Chairman, Hilton Parish Council

Hilton A14 - Further Statement

A14 Cambridge to Huntingdon improvement scheme

Statement of Common Ground between Highways England and Hilton Parish Council

**HILTON ROAD WORK NO. 16 -  
WORKS PLANS SHEET NO. 14**

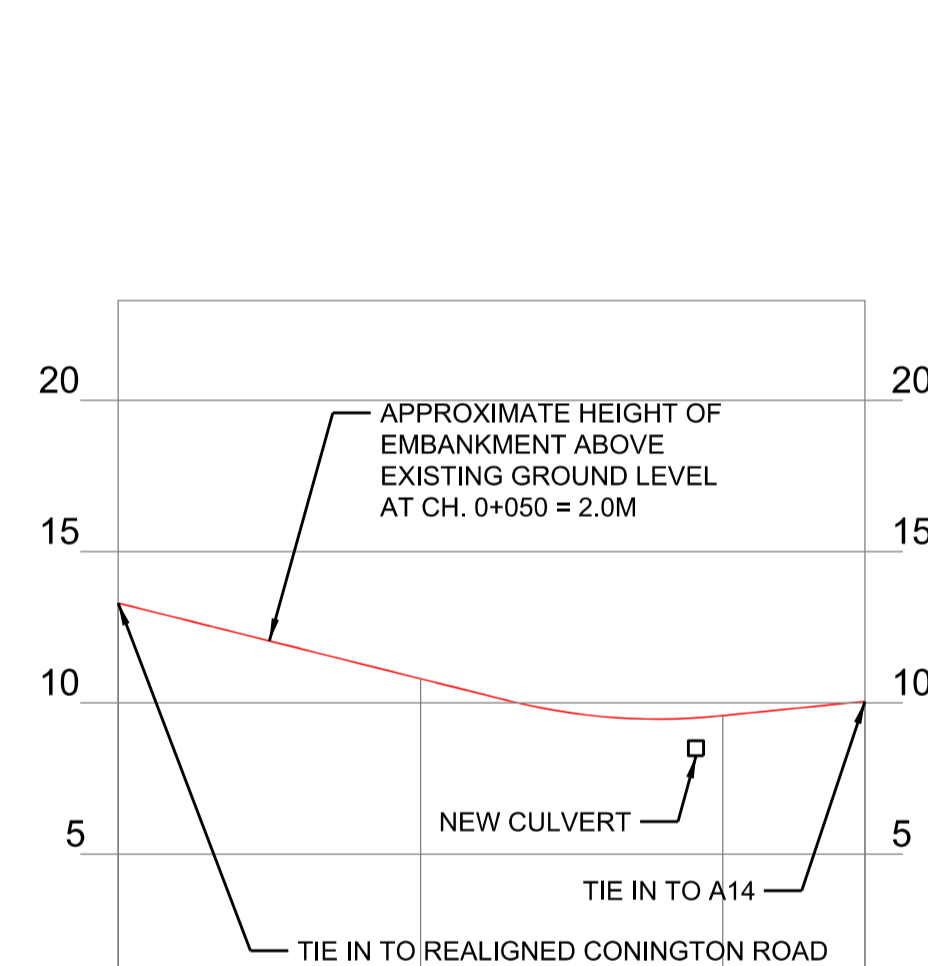
4	Design and Engineering Standards Height of overbridges	Clarification is required on actual height of bridges above existing ground level. The Potton Road and Hilton Road bridges appear to be up to 2	There is scope for refinement at detailed design stage when exact structural options are determined. There will be opportunity for consultation	Under discussion.

<p>metres higher than what is actually required with Potton Road at 11m; and Hilton Road bridge at 10.7m. More detailed engineering drawings are required and engagement at the detailed design stage.</p> <p>Highways England subsequently stated the additional height is due to the single span of the bridge across all six lanes with no central support.</p>	<p>and engagement during detailed design stage, at which stage there will be opportunities to comment on designs.</p> <p>At detailed design the elevation of side roads crossings will be minimised to reduce both impacts and costs. Please refer to Appendix B.</p> <p>In the meantime we will continue to discuss the height and appearance of structures with you.</p>	
5	Landscape and visual effects	<p>Concerns regarding the visual impact and appearance of structures along the route.</p> <p>Hilton Parish Council request to get the best mitigation possible for the people of Hilton.</p> <p>Hilton Parish Council also questions the rules and guidelines which Highways England contractors will have to work to.</p> <p>Hilton Parish Council are concerned about the impact of light pollution from high sided vehicles hence the wish for a higher barrier up to 4m in height.</p>	<p>In view of the concerns raised about visual impacts as the road passes Hilton (in particular relating to the Potton Road over bridge), a desk study has been undertaken to identify a proposed additional and representative viewpoint on the north edge of the village which places the overbridge clearly in view without intervening screening. It is to show the proposed scheme and the Potton Road bridge before construction and at year 1 and year 15 after construction.</p> <p>This viewpoint was shared with Hilton Parish Council and a site meeting was held with the Parish Council on 3 June 2015 to assess the suitability of this and potential alternative viewpoints suggested by the Parish Council. The Parish Council concurred that Highways England's proposed viewpoint is suitable for an additional photomontage.</p> <p>The photomontages from the agreed viewpoint can be found within Highways England's Response to the First Written Questions</p>	Under discussion.

As set out in Highways England’s response to the First Written Questions, Question 1.9.9, the majority of the new bridge structures on the scheme, including those on the Huntingdon Southern bypass section, are similar in nature and have been developed as a family of structures known as the ‘Standard Overbridges’.

The typical height of an overbridge is 11.2 metres above ground level, this height is a summation of the following requirements:

1. The height of the mainline above ground level is driven by drainage requirements;
2. A 5.3 - 5.7 metre headroom is required under the bridge to accord with design standards (this depends on the structures impact resistance, so the scheme uses 5.7 metre structure to keep structure options open);
3. A structural depth of 2.0 metres is typically required (dependent upon the structure type and span);
4. Allowance for construction on bridge;
5. Allowances for road crossfall, gradient, construction and settlement etc.

- $3\text{m} + 5.7\text{m} + 2\text{m} + 0.5\text{m} = 11.2$ metres above ground level.
